Subject: A/55/19/PL

A/55/19/PL is exactly the same as the previous refused application A/31/19/PL.

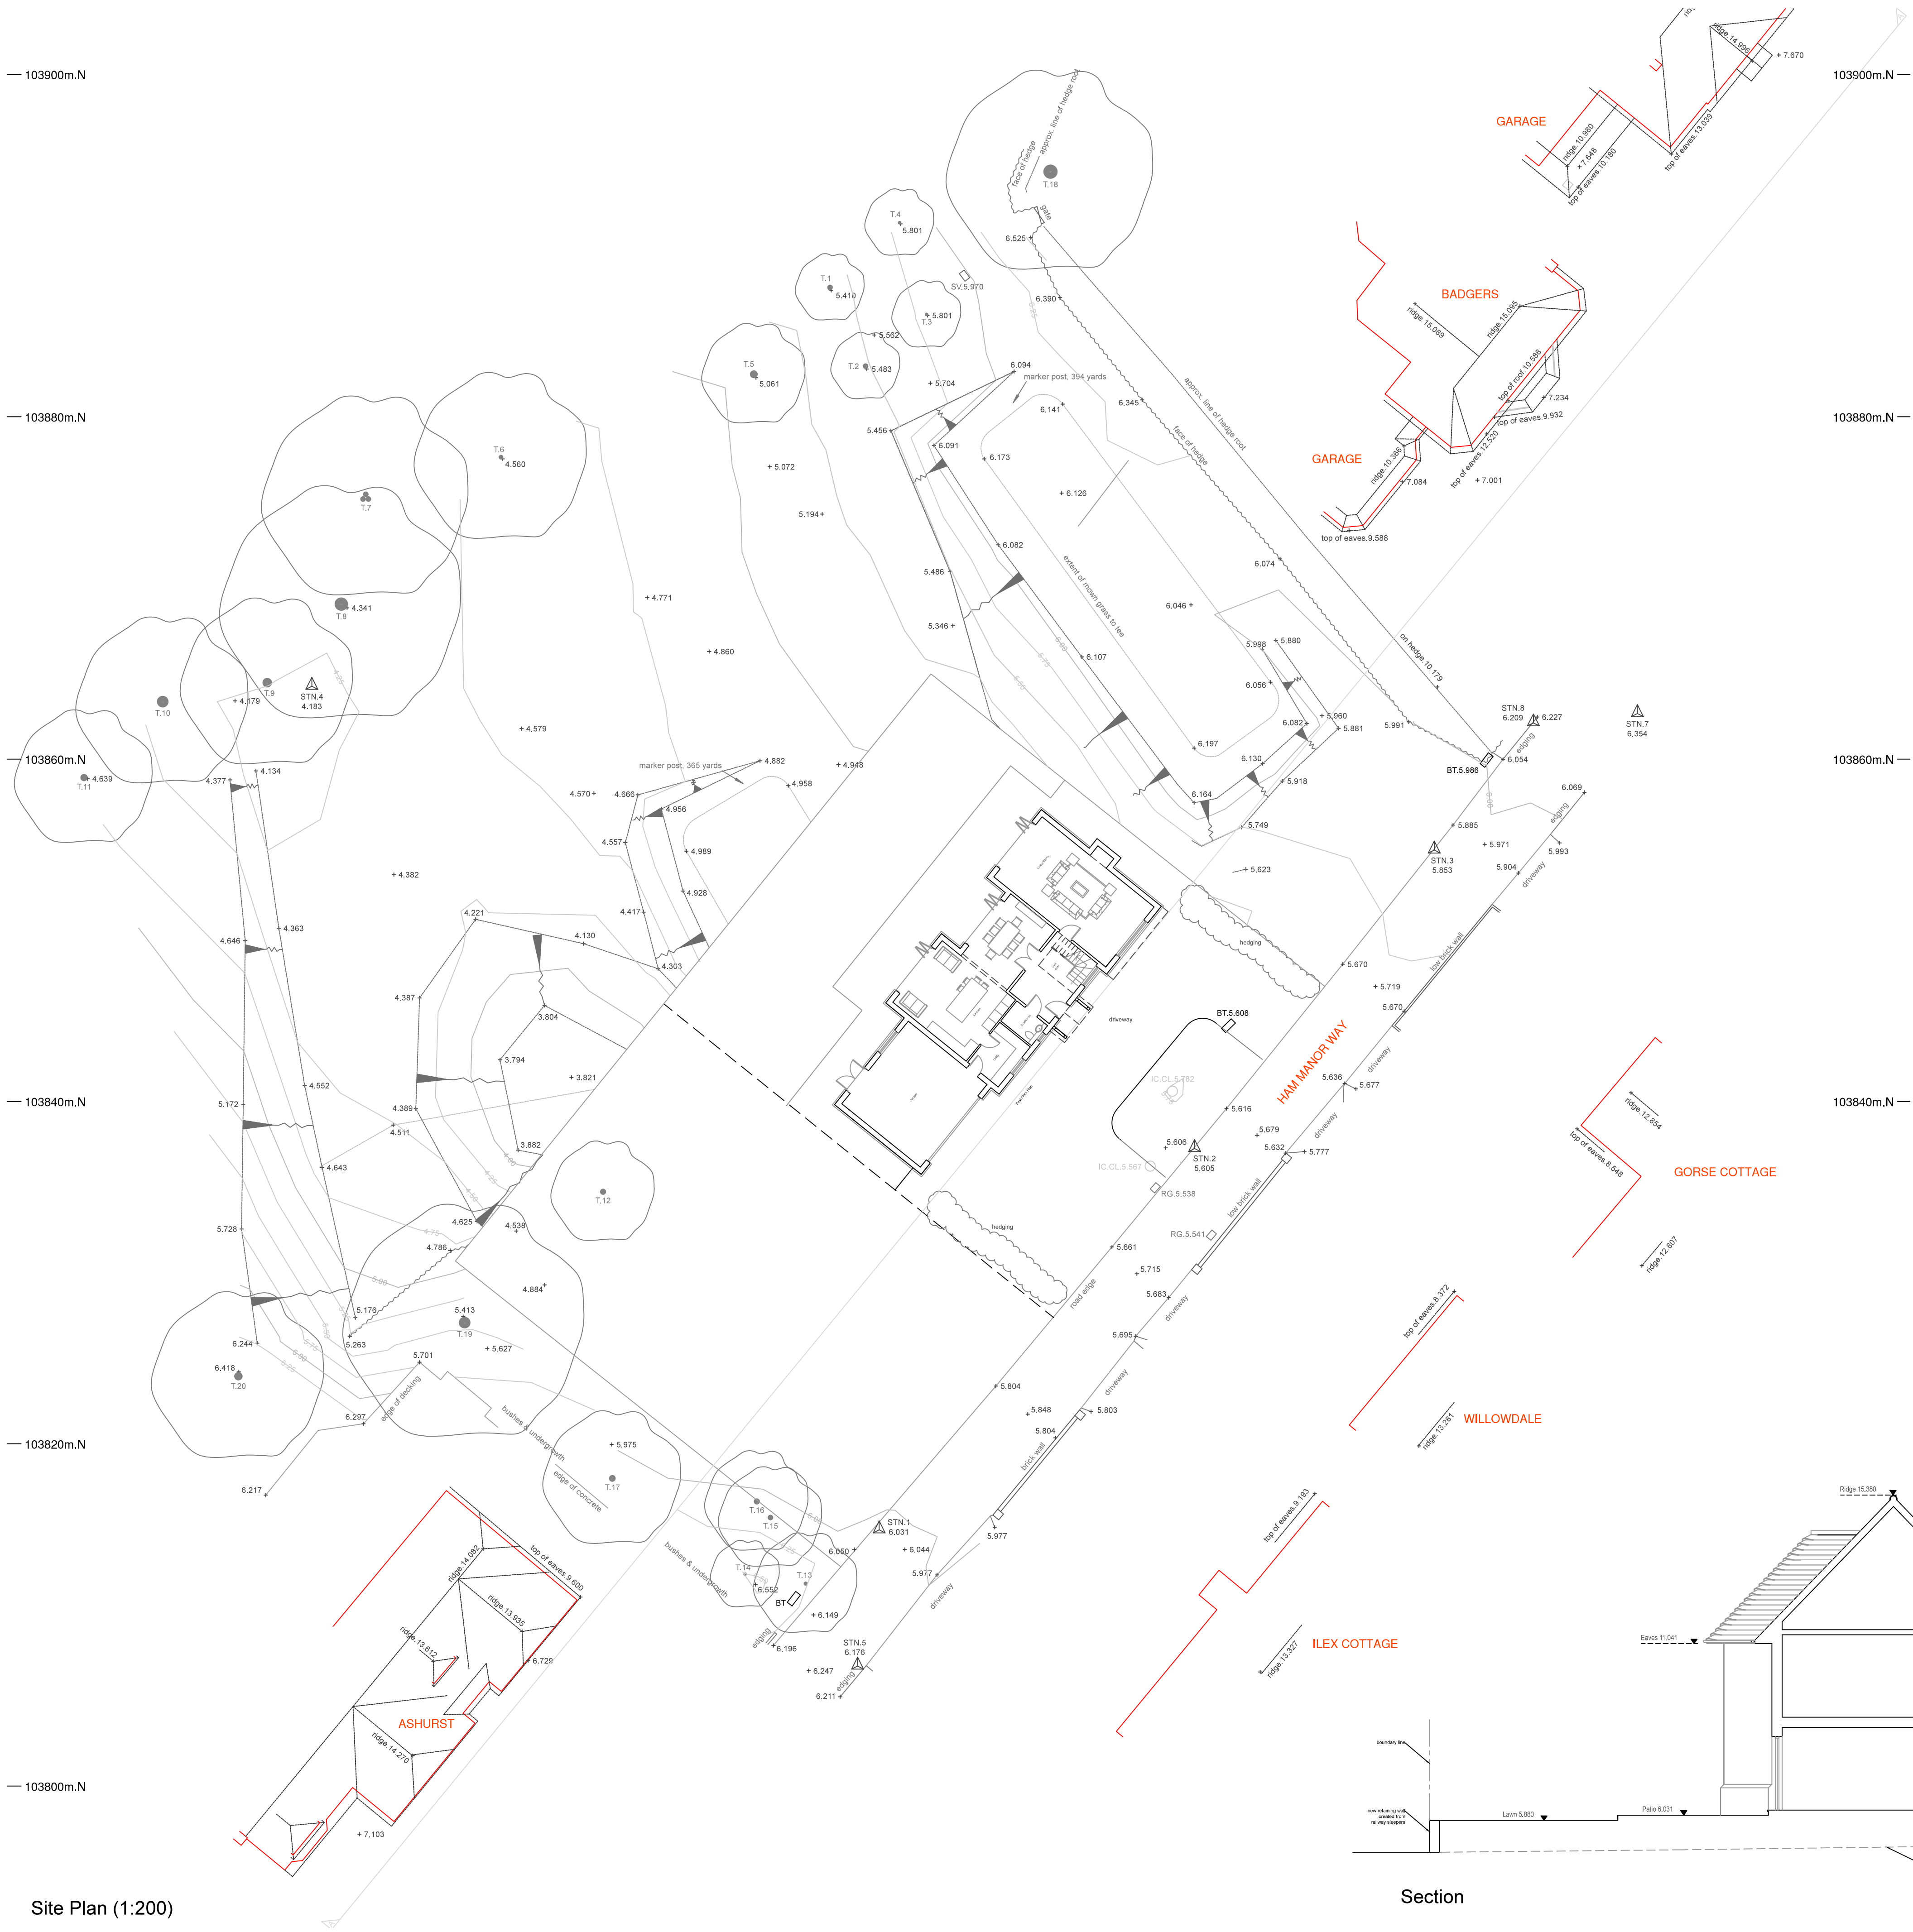
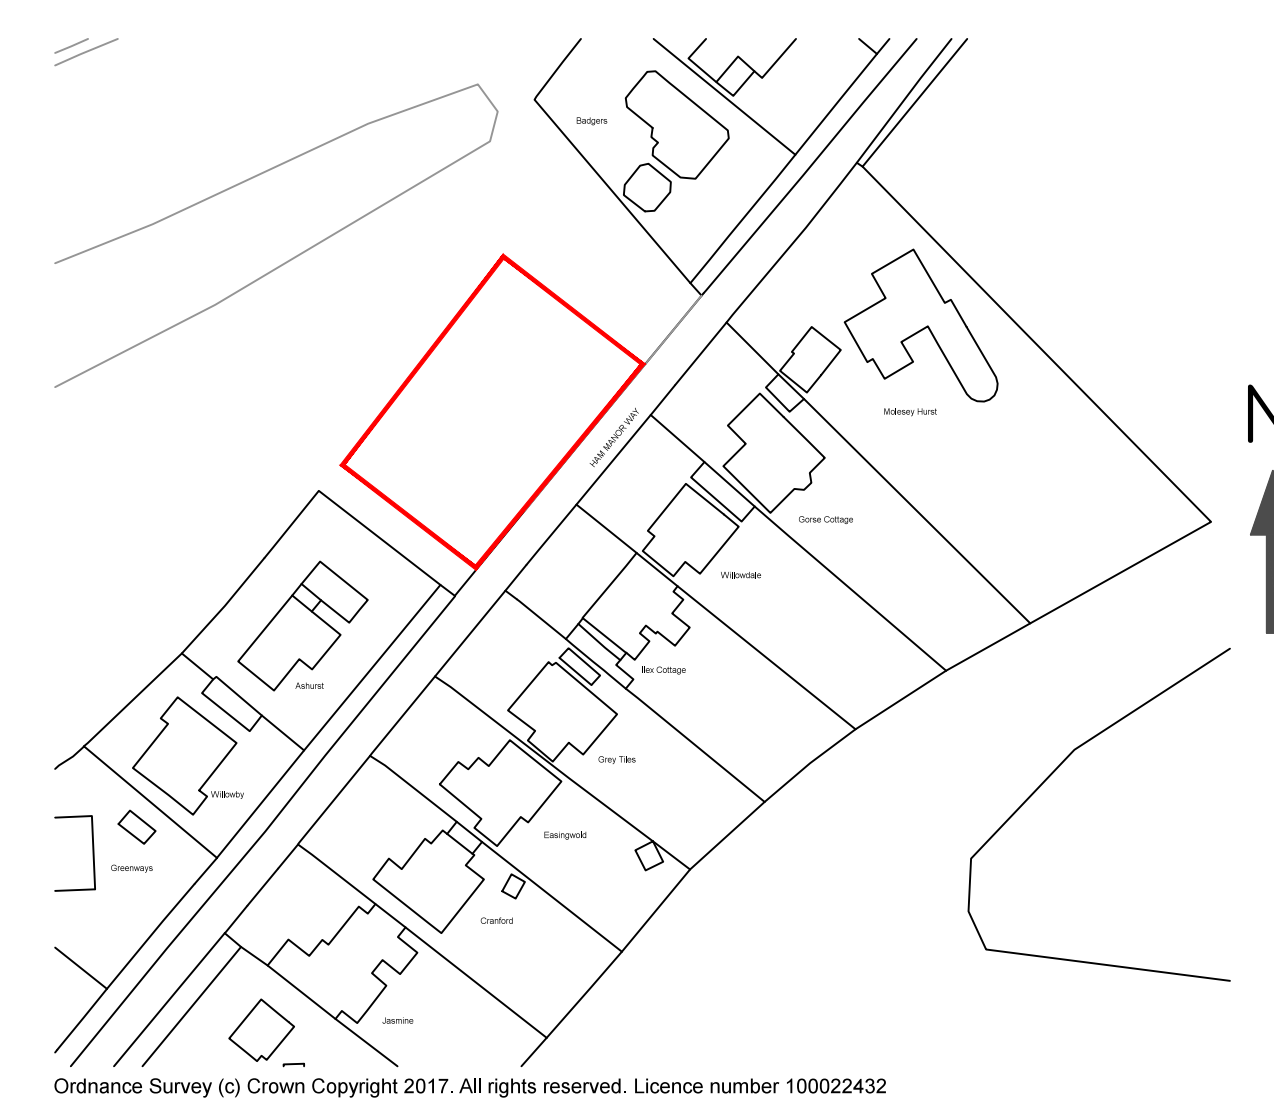
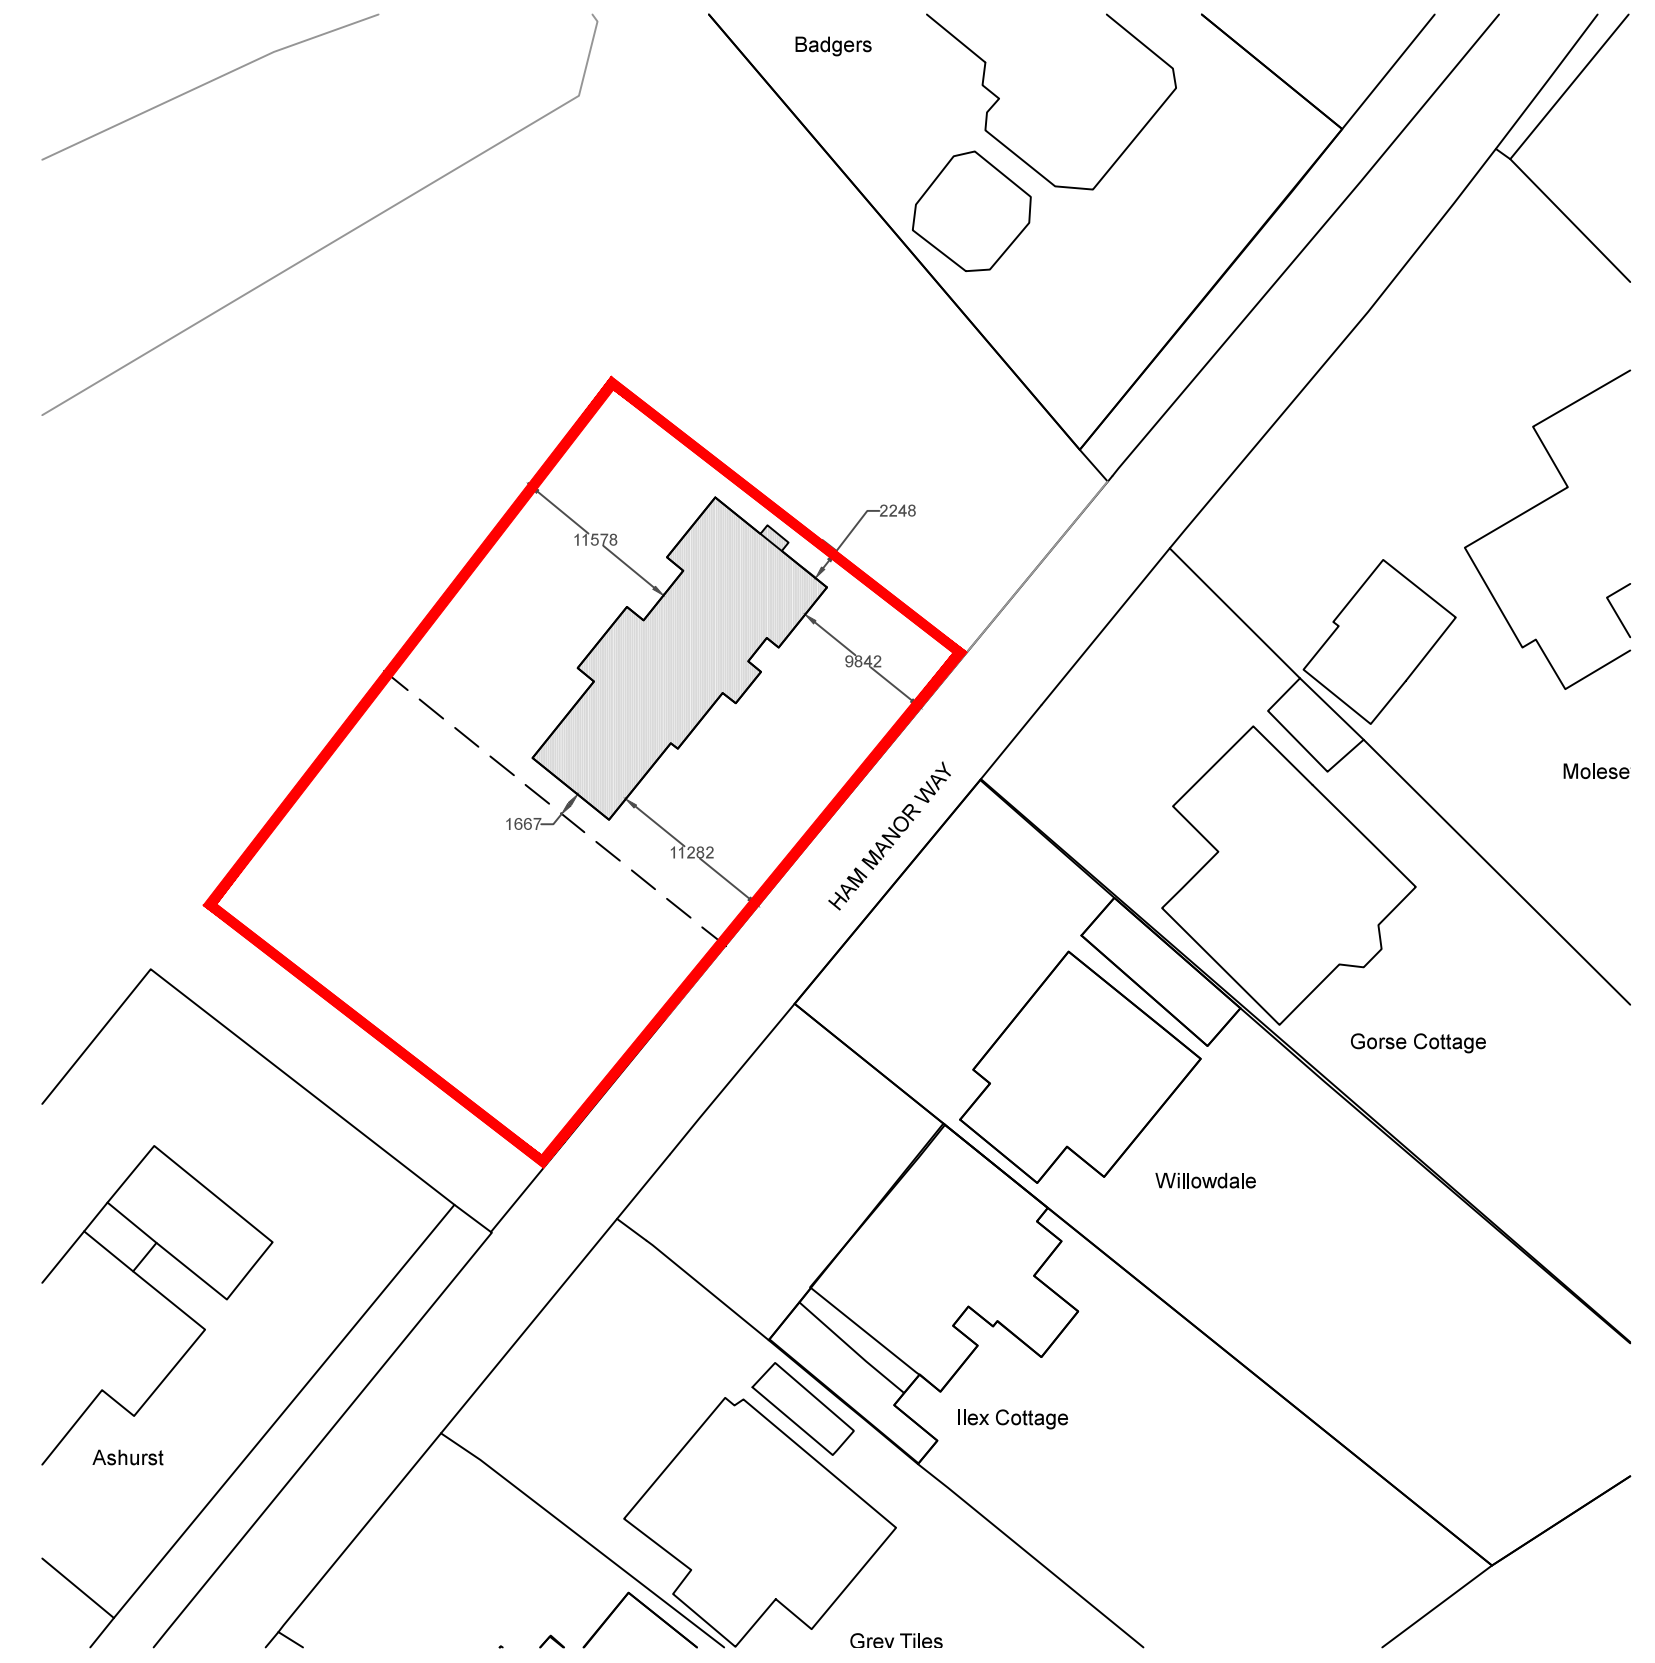
It has moved the 2 m way from the Ashurst boundary requested in your Recommendation Report. However it has moved further out on the western boundary taking it into local green space.
